From: Mark Warwick
Sent: 07 August 2018 15:28
To: Anita Gardner
Cc: Planning.Responses
Subject: RE: Waterbury House, 8 -10 Ford Road, Arundel HT25712

Planning Application Ref: **FP/10/18/PL**

Location: Waterbury House, Ford Road, Ford

Description of works: Construction of 5 No. 1 bedroom flats together with staff accommodation, hard landscaping & parking, (resubmission following F/29/17/PL). This application affects the setting of a listed building & is a Departure from the Development Plan.

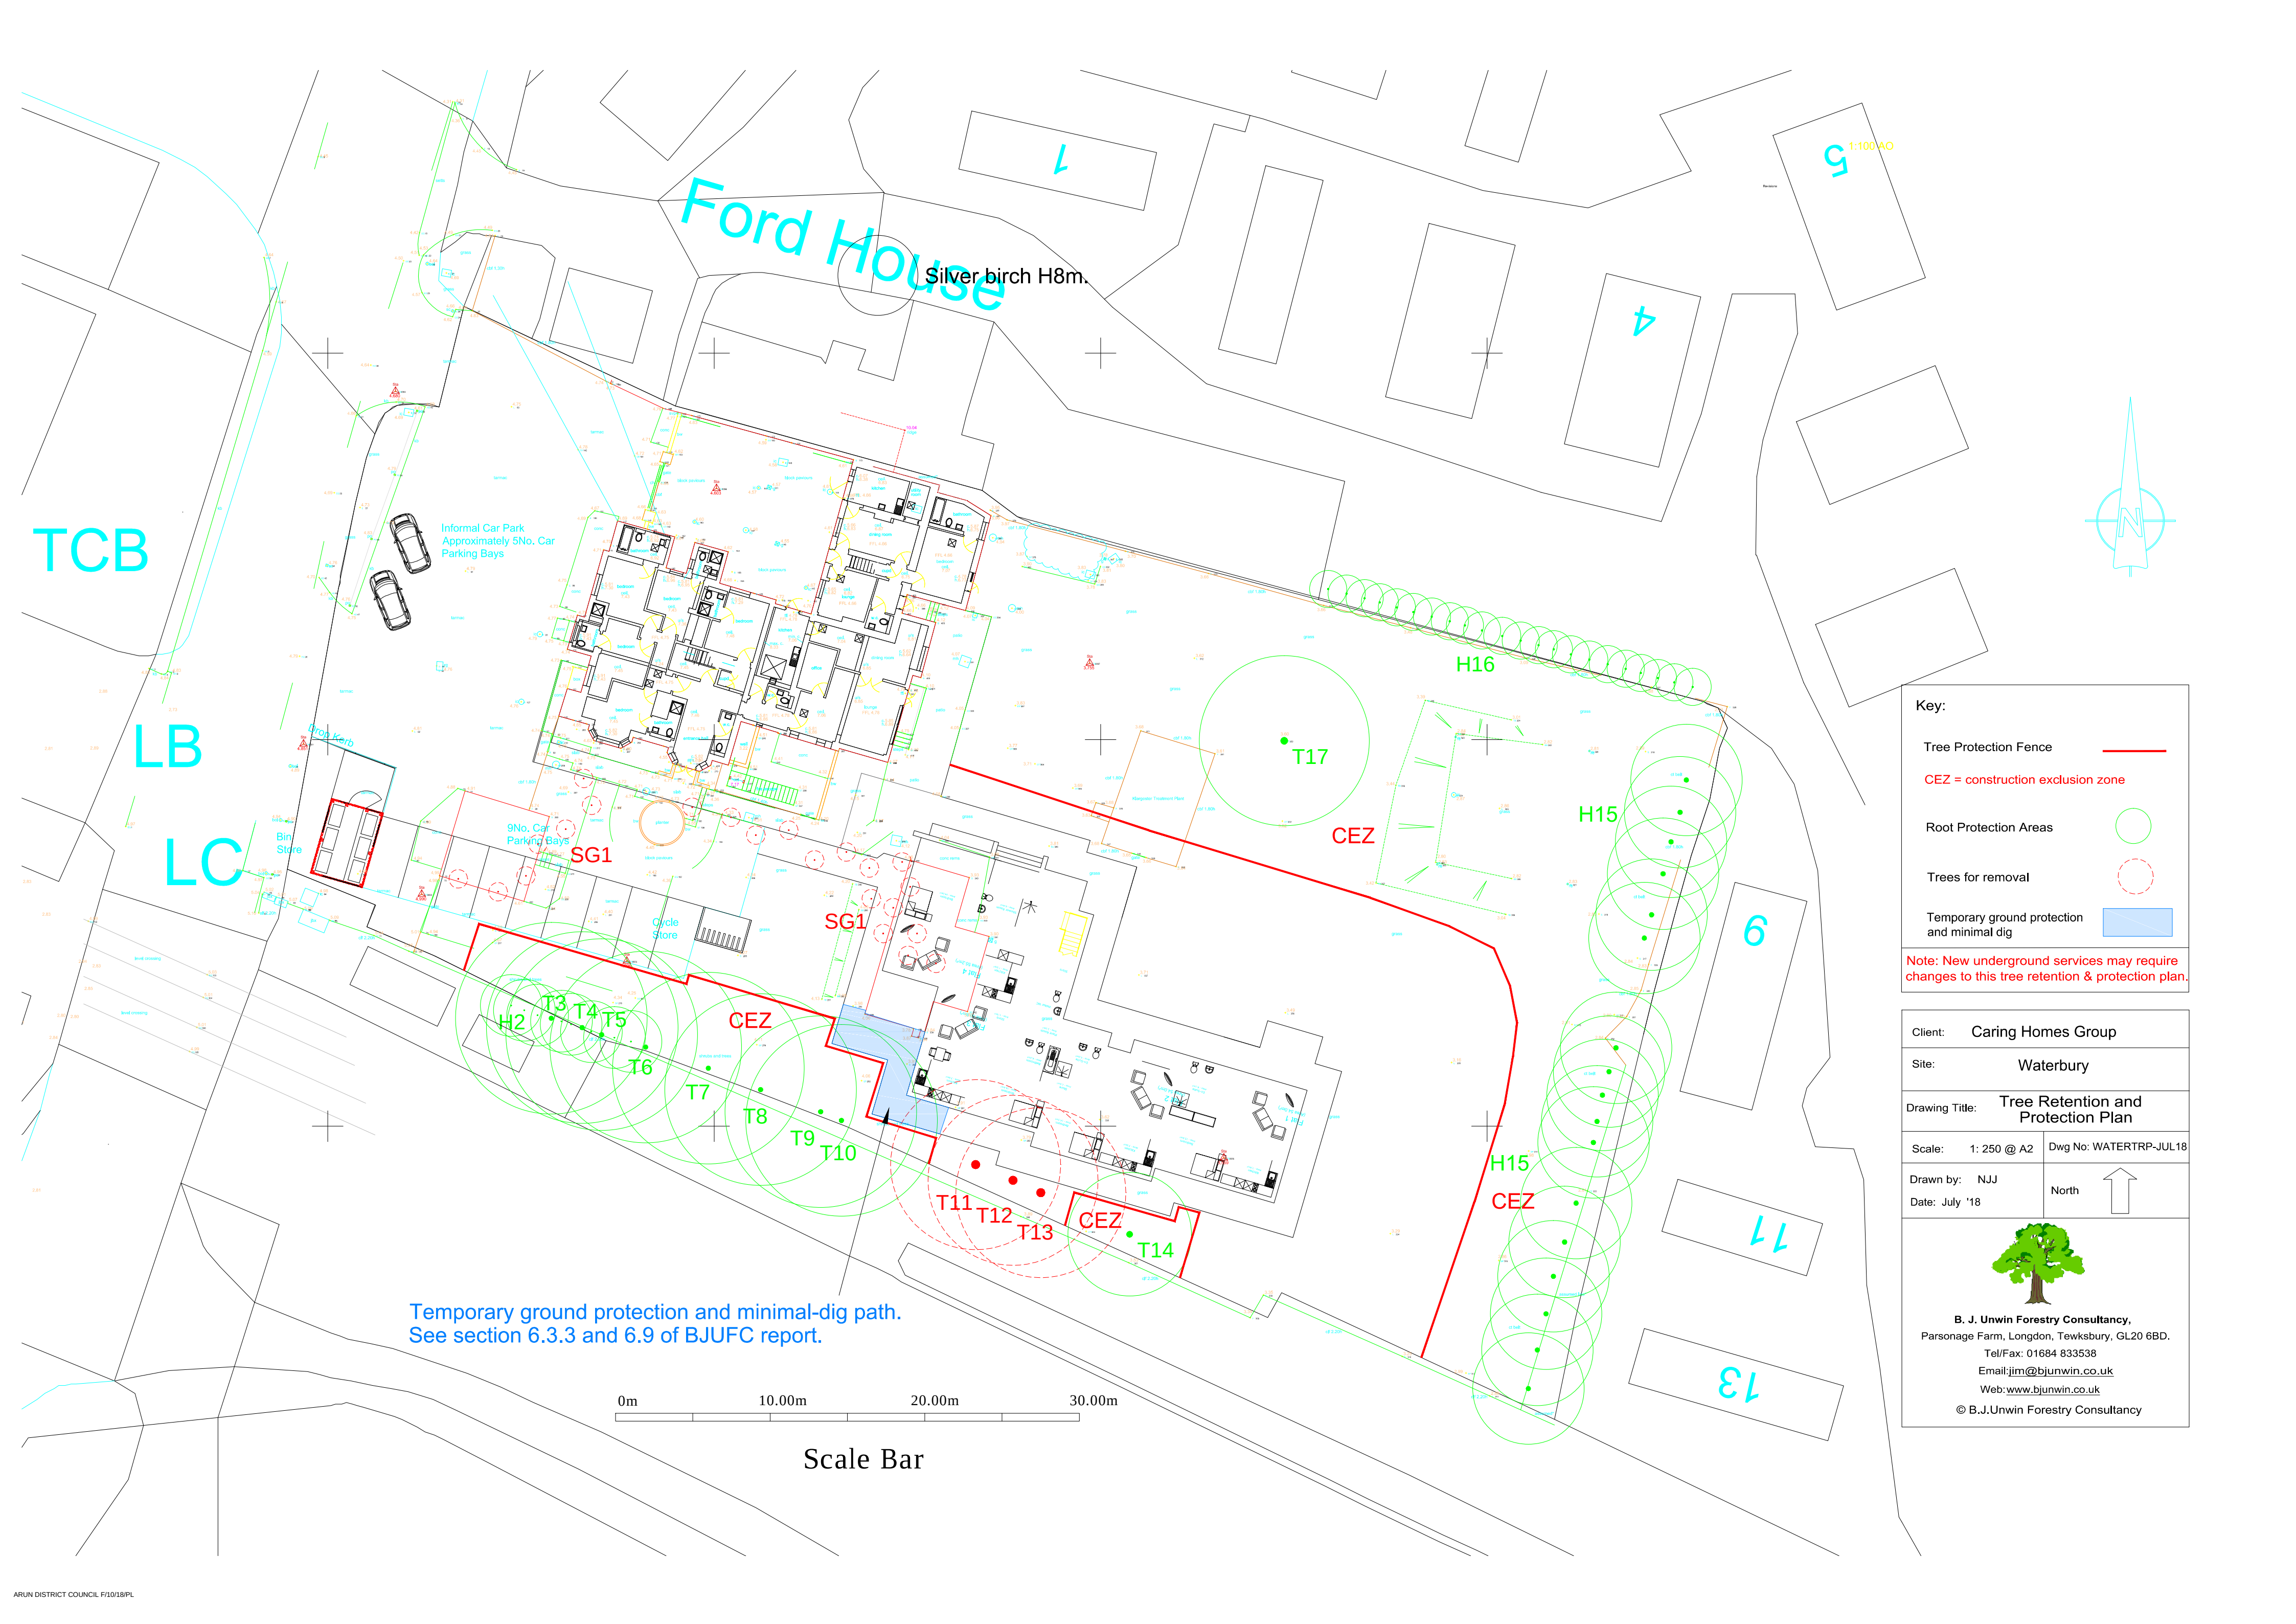
- Before the site is occupied or any machinery is introduced to the site or demolition work or construction work or alterations to existing ground levels takes place a **PRE-COMMENCEMENT Site Meeting** is to take place between the Arun DC Tree Officer and the Arboricultural Expert representing the site owners – at this meeting all protective fencing will be inspected along with ground protection measures – they will be assessed to verify that they are 'Fit for Purpose' as required under British Standard 5837:2012 and have been erected and positioned exactly as shown on the **Tree Retention and Protection Plan Dwg-No: WATERTRP-JUL18**
